An
Bord
Pleanála

Board Direction
BD-012078-23
ABP-313362-22

Re: Amending Board Order

The Board decided that it is appropriate to amend condition 2 (a) due to a clerical error in respect of the annotations of the blocks within the scheme whereby as per the assessment within the Inspectors report the blocks to be omitted should have read Blocks C & D and Duplex Block V rather than Blocks B & C and Duplex Block V.

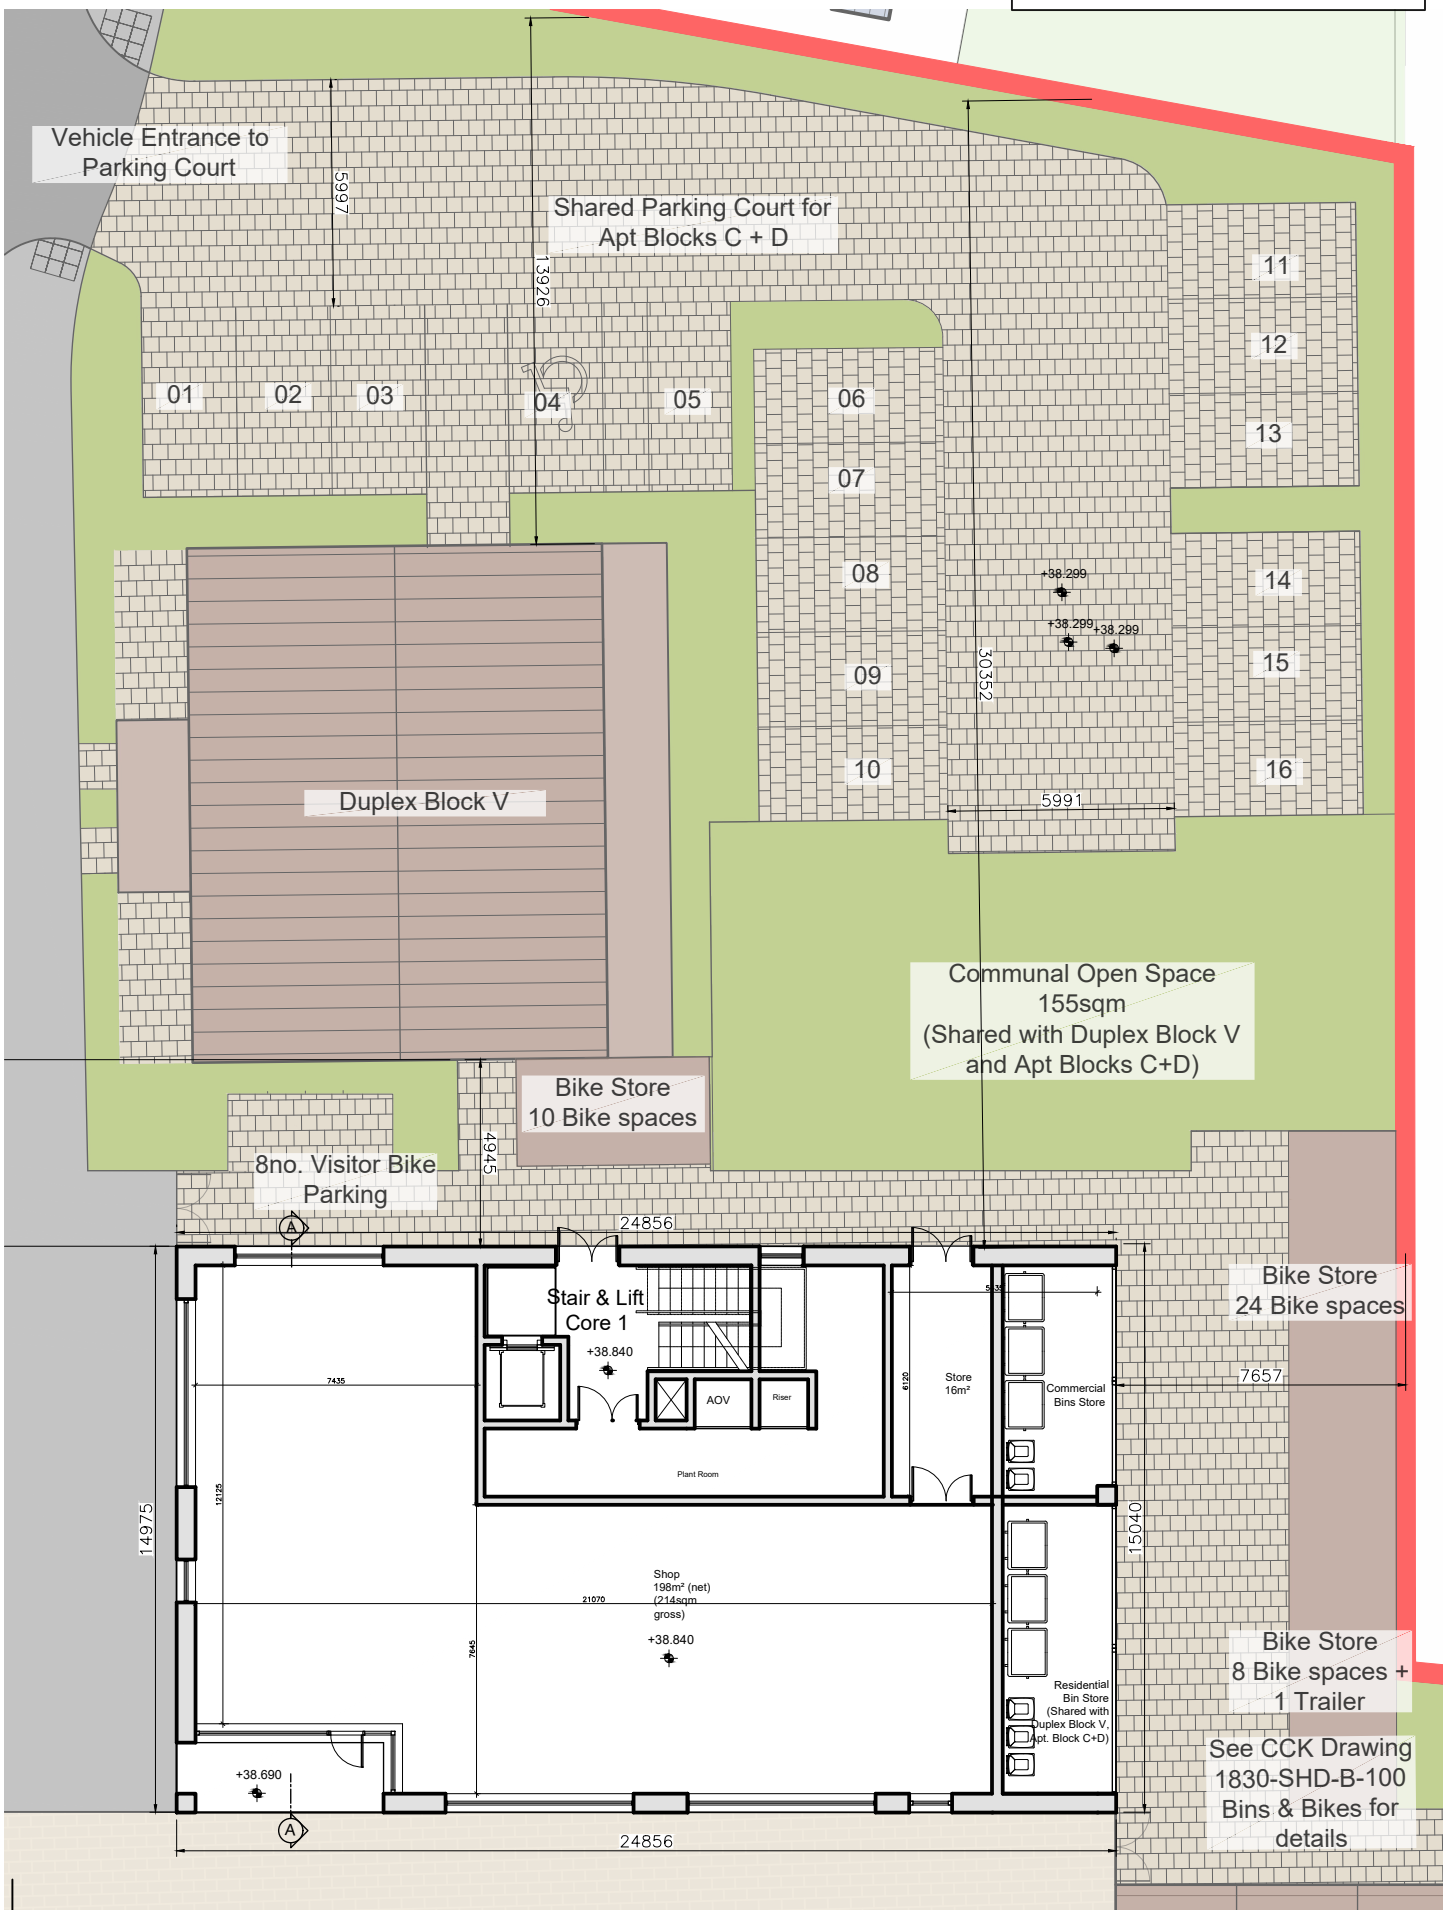
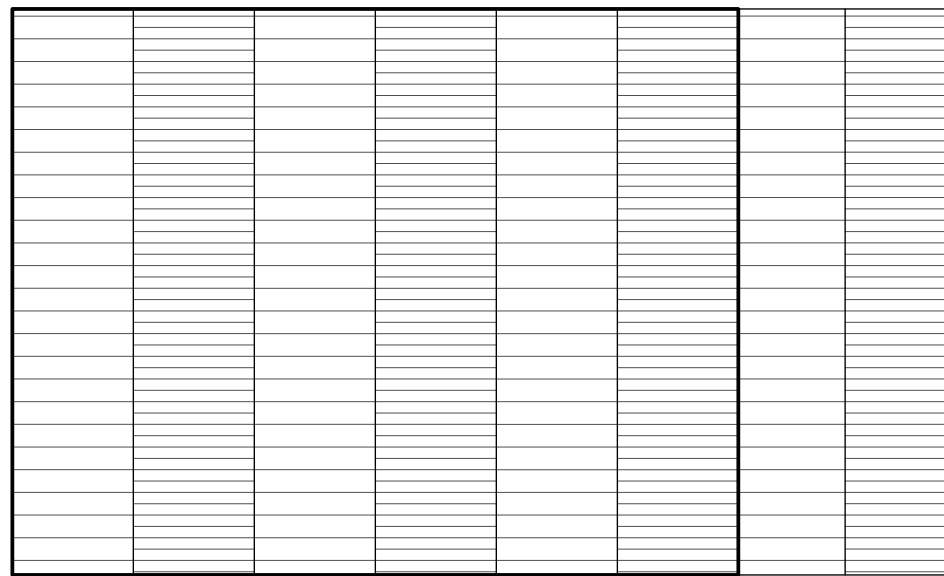
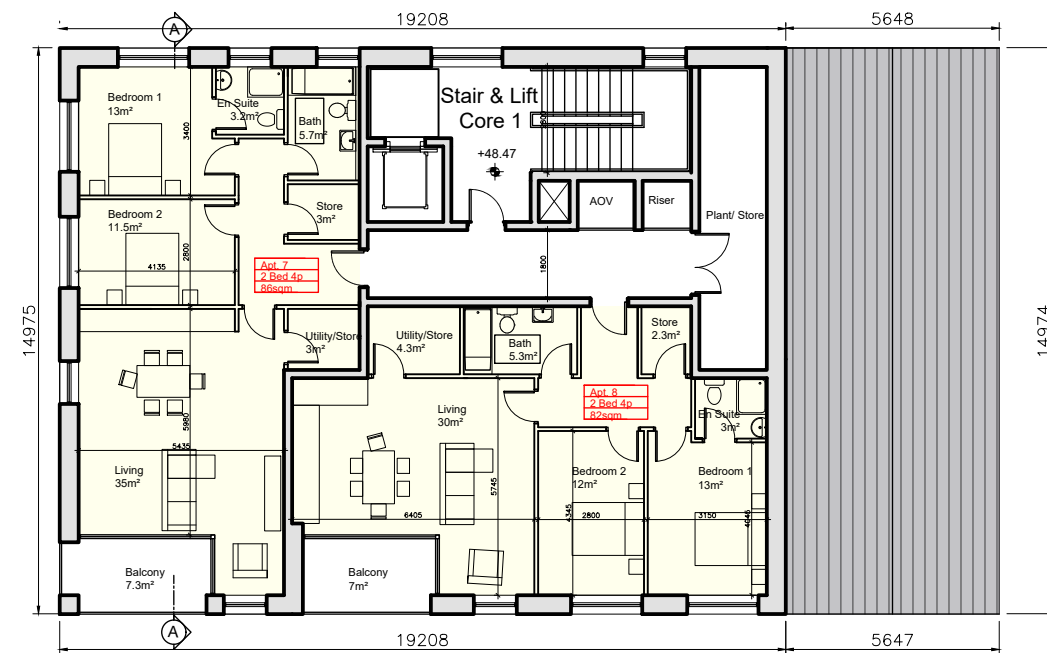
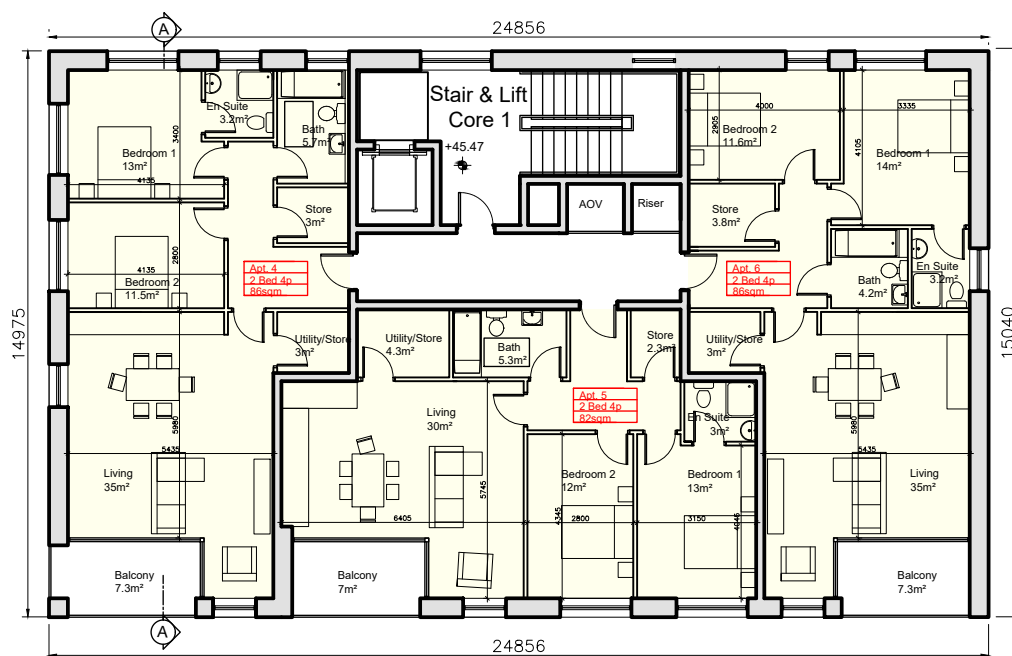
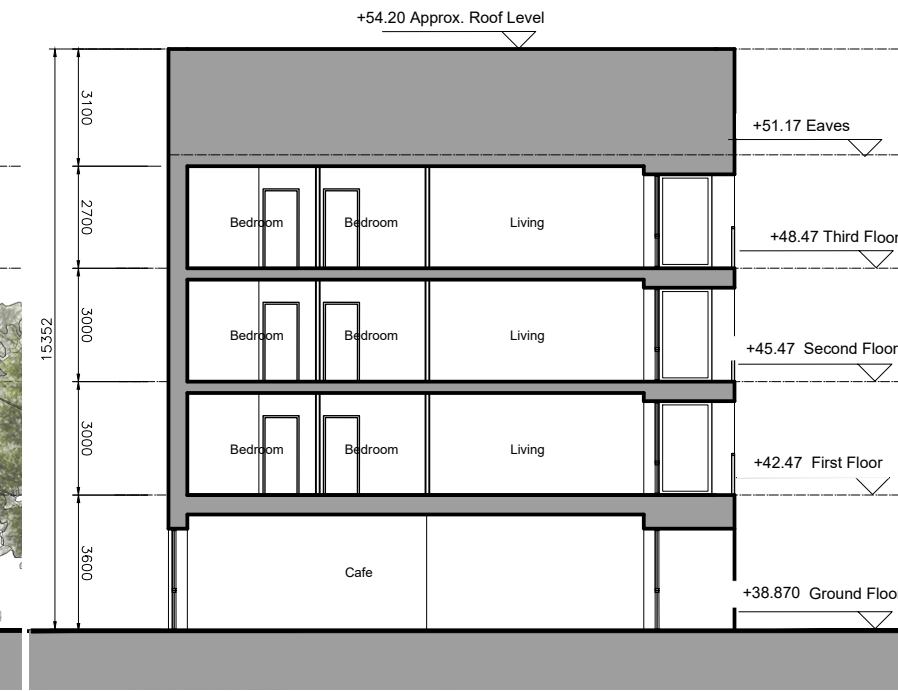
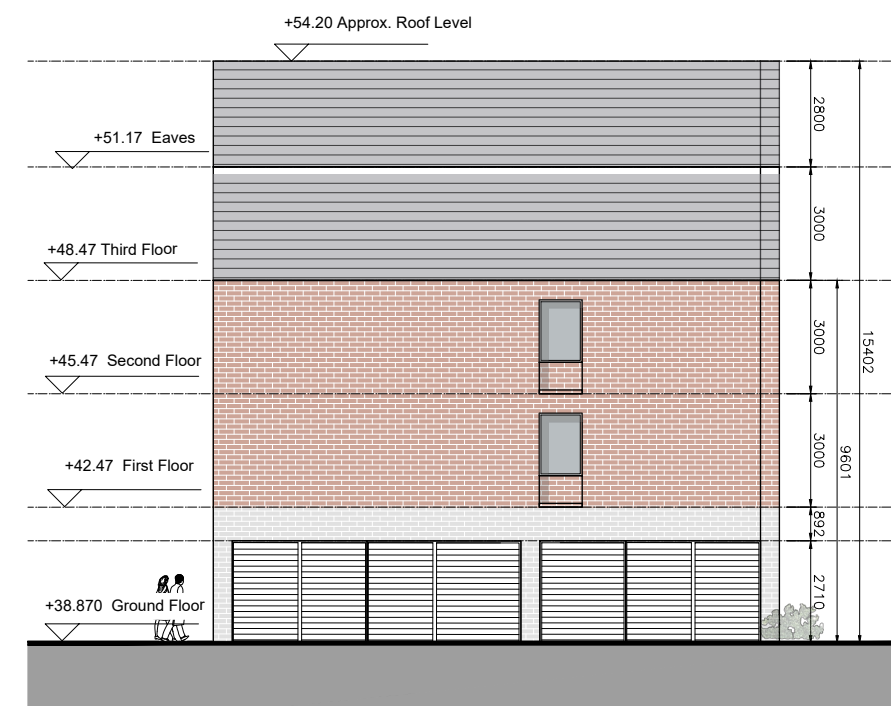
- a) Urban Block 03, which comprises Apartment Blocks C and D and Duplex Block V, shall be omitted and replaced with public open space unless and until such time as permission is granted for future development in this location.
- b) The junction of Road 10/Mooretown Distributor link extension shall be redesigned to cater for walking and cycling access only.
- c) The width of the entrance lobby in Apartment Block E as it adjoins ground floor Unit 3 shall be increased to a minimum width of 1.2m. This may require minor amendments to the design and layout of the Unit 3.

Revised drawings showing compliance with these requirements shall be submitted to, and agreed in writing with, the planning authority prior to commencement of development.
